Your Ref: OWPC17265
Our Ref: EG/107/17/DOC 21-12-2017
Please ask for:
Mr S Davis

Application for approval of details reserved by condition imposed under planning application EG/38/15/PL relating to condition No. 3 - Surface water drainage
97 Barnham Road Eastergate

Thank you for your internet representation made on 5th February 2018 which has been recorded as '**an objection**' with the comments as follows:

Number
S17-03-01 E

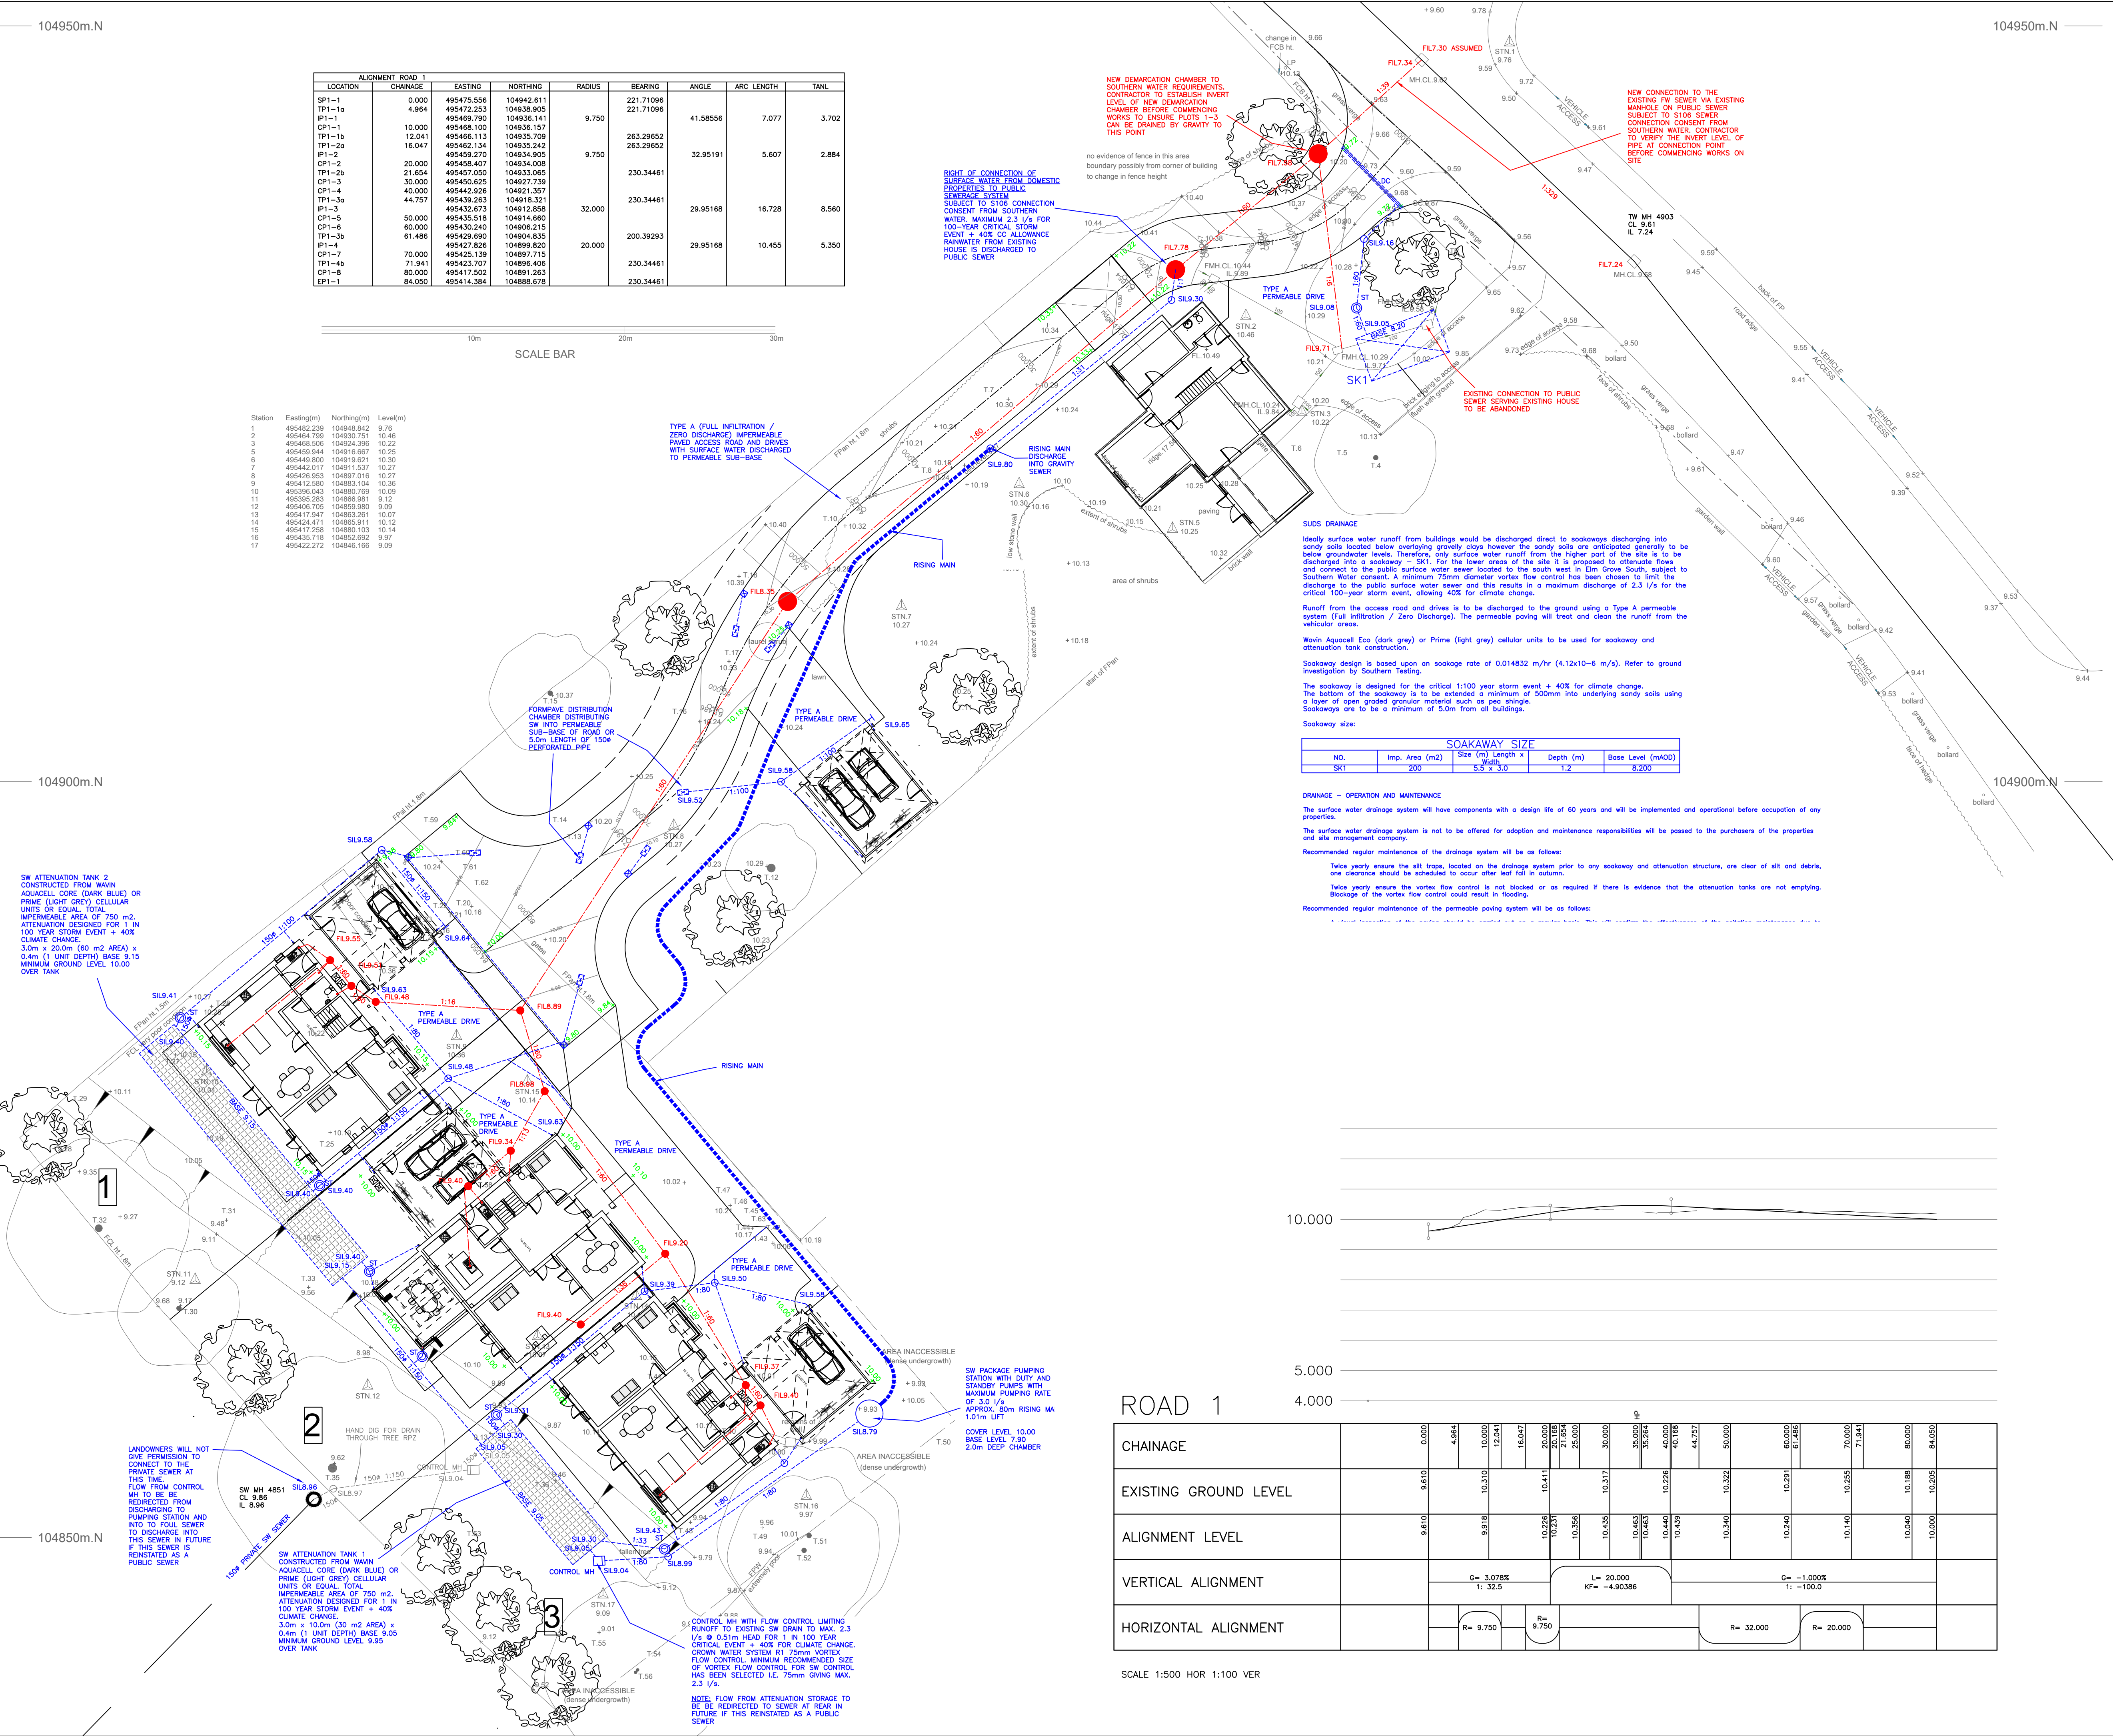
I refer to the above application I would object to the proposal because this application is applying to connect to our private surface water sewer in elm grove south the man hole and pipework shown on the site drawing do not exist this manhole and pipework was disconnected over 30 years ago at this time the surface water from elm grove south discharges to a water course via a private surface sewer which then runs to a pond the discharge from this pond has been collapsed for a long time and the pond floods onto the farmers fields and blocks the public footpath this application should not include approval to connect to the drain in elm grove south but should be treated as a separate issue to be addressed should needs be. I further refer to the drainage to the rear of the site and refer to the letters from mr callaway dated the 27th august 2015 and the 7th December 2016 regarding percolation tests and a reply from mr m.j. Harvey I am not happy that the percolation tests were carried out over a winter period allegedly the figures used are from a desk study I am concerned that water not accounted for will percolate to under our houses and undermine the foundations to our properties in elm grove south and cause structural problems in the future.
